From: Richard Wallis [REDACTED]
Sent: 13 October 2021 11:37
To: Anita Gardner <Anita.Gardner@arun.gov.uk>
Cc: Bruce Howse [REDACTED]
Subject: Re: A/180/21/DOC - Mayflower Way, Angmering - Construction Management Plan

Subject: A/180/21/DOC - Mayflower Way, Angmering - Construction Management Plan

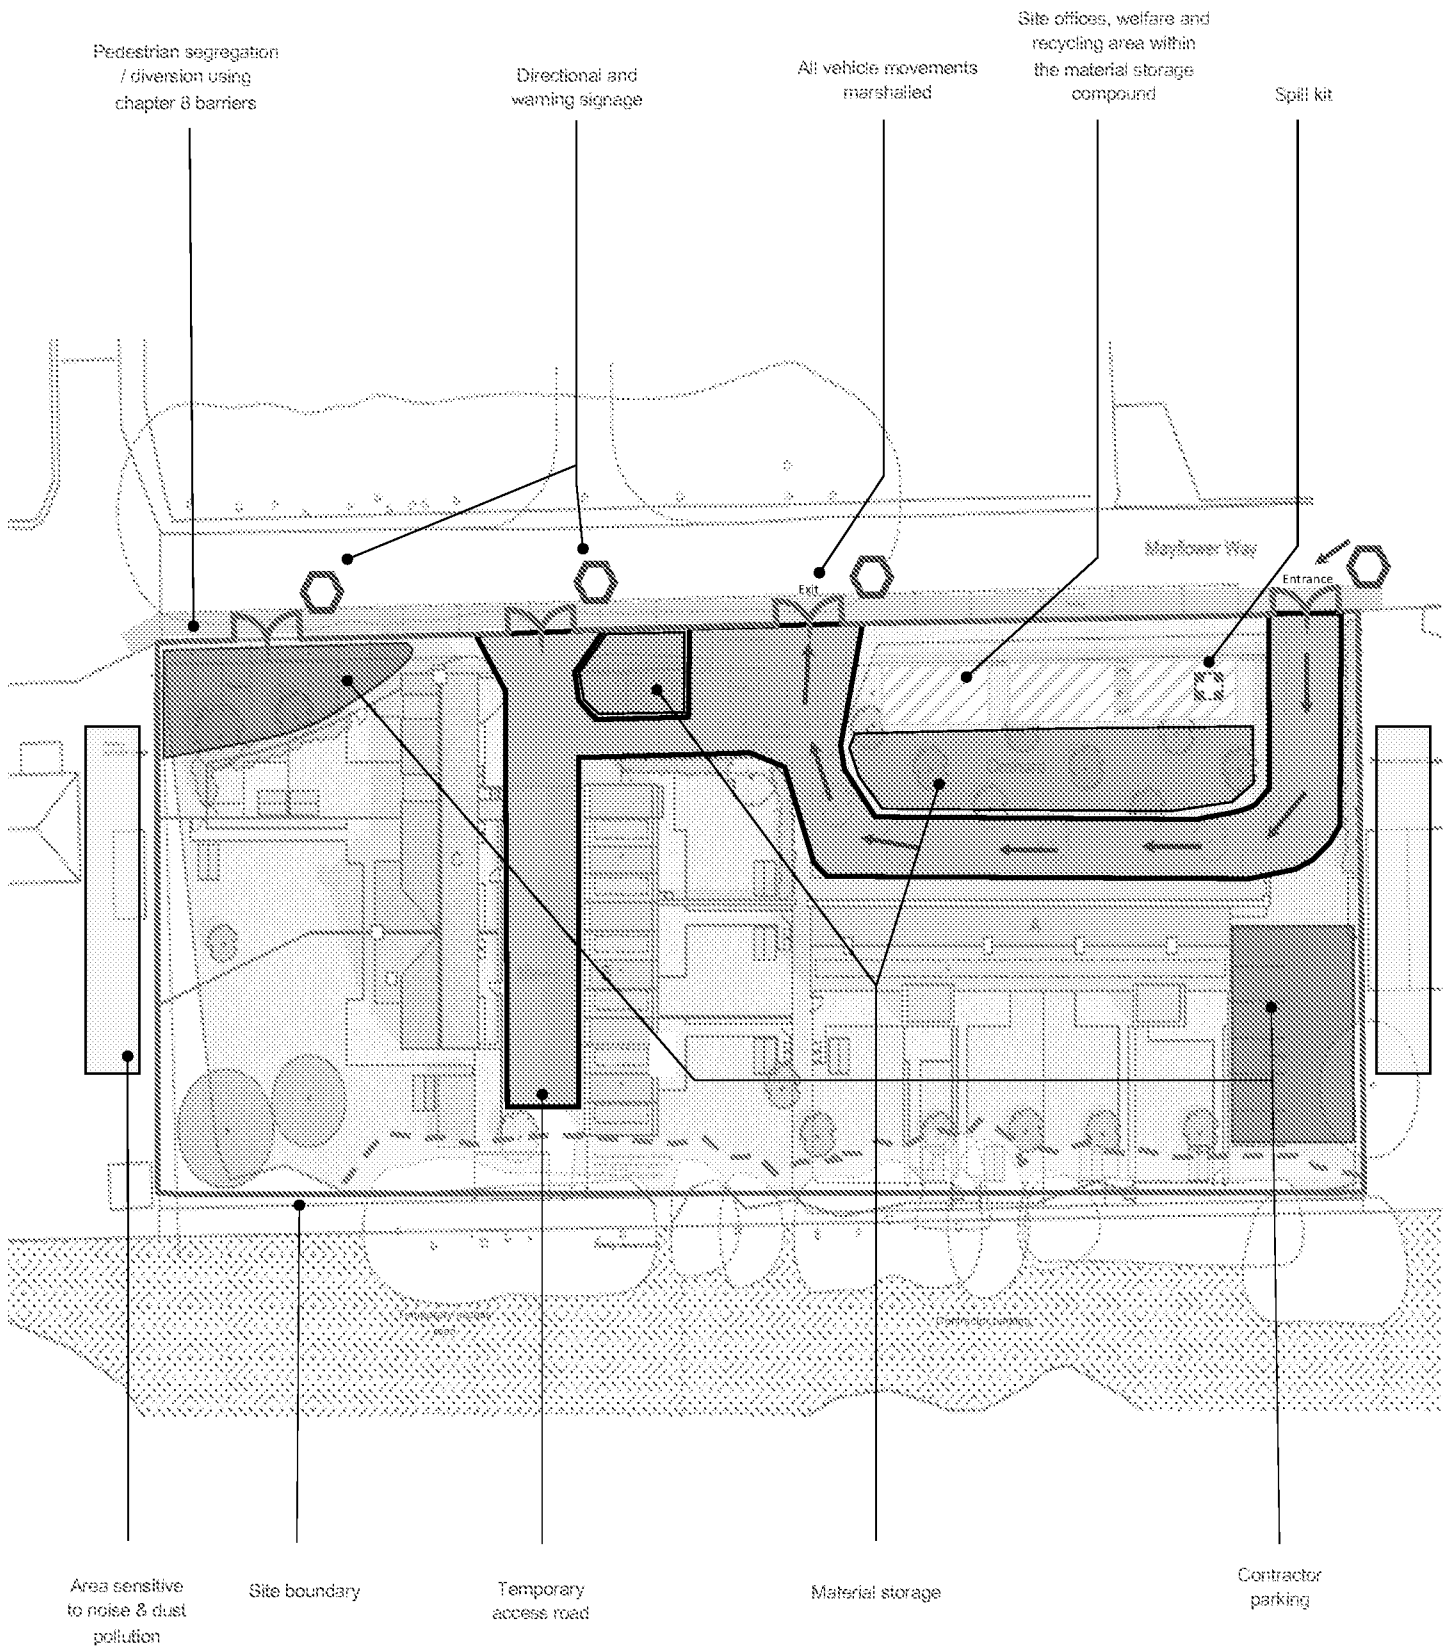
No agreement to discharge of Condition 6. The applicant will be aware of the predominantly peaceful nature of this area. It is therefore of concern to note that both access to the site materials storage area, (which will include HGV deliveries/taking away) and to contractor car parking is proposed along the boundary with a bungalow/housing to the immediate east of the proposed new housing. There is a similar, but smaller, area of contractor parking proposed immediately onto the boundary with that property to the immediate west of the site.

The location of the site access way/materials storage is therefore far from ideal and in my opinion likely to result in noise detriment/nuisance to nearby sensitive receptors. I would request for the site access way and main materials store to be repositioned to a more central position along Mayflower Way. Perhaps, it would then be possible for the main area of contractor parking to be brought forward towards Mayflower Way to form a buffer to this bungalow. Please could the applicant describe the type of vehicles which will be included in 'contractor parking' ie will this be for vans and private cars alone/other.

I would therefore request that you submit a revised site layout plan and details to address these concerns within the next 10 days. I would appreciate your agreement to an extension of time on the application until 10-11-2021 to allow for submission of revised details and re-consultation.
